**Planning (Listed Buildings and Conservation Areas) Act 1990 (as amended)
Planning (Listed Buildings and Conservation Areas) Regulations 1990 (as amended)
Application for Listed Building Consent for Alterations, Extension or Demolition of a Listed
Building**

Development Application for Listed Building Consent to replace 3x PVCu windows with all wood versions to match the rest of the house.

Location Ancton Manor Ancton Lane Middleton on Sea

SITE LOCATION PLAN
AREA 4 HA
SCALE 1:1250 on A4
CENTRE COORDINATES: 497990, 100646

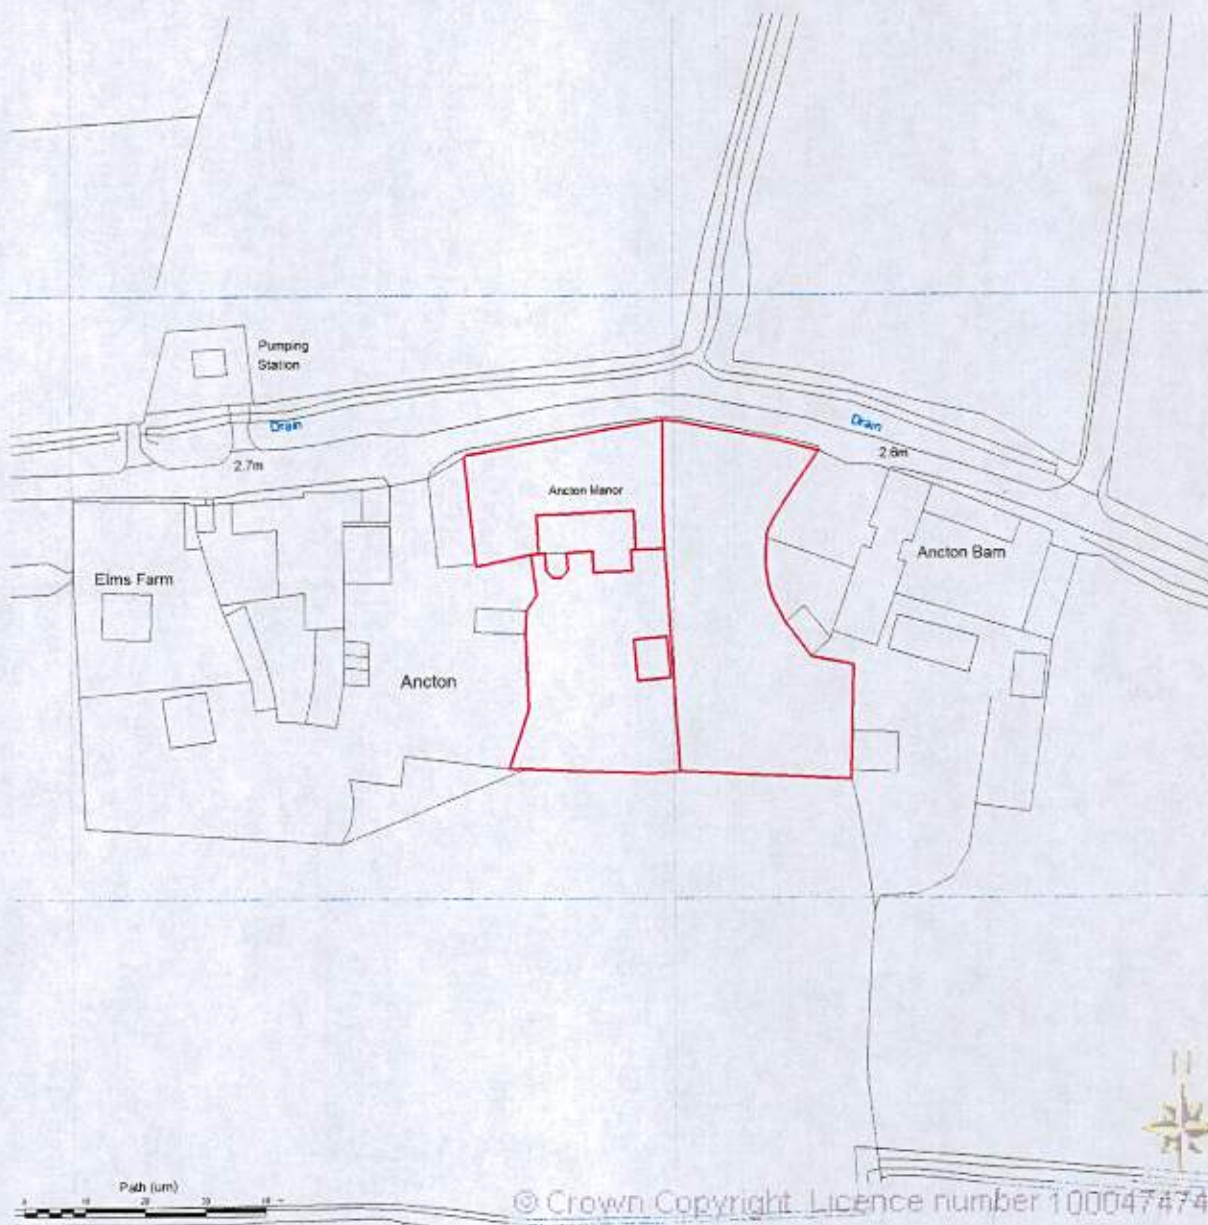
Please provide copies of a revised block plan clearly showing the position of the windows that this application relates too.

PROPOSED
4-6-4

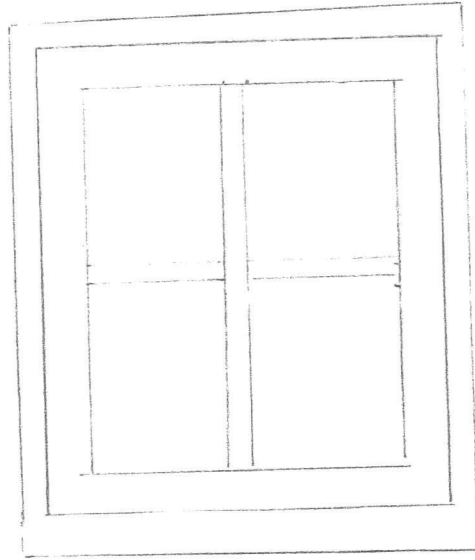
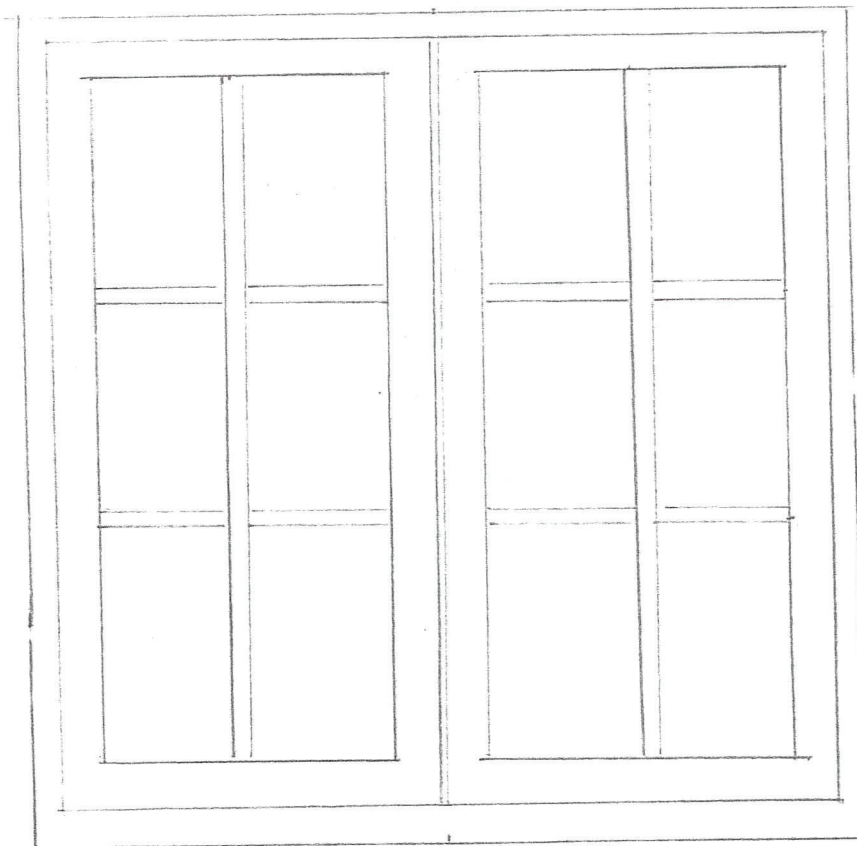
Please submit amended 'proposed' drawings showing exactly what the windows will look like. Photos of windows already in situ will not suffice.
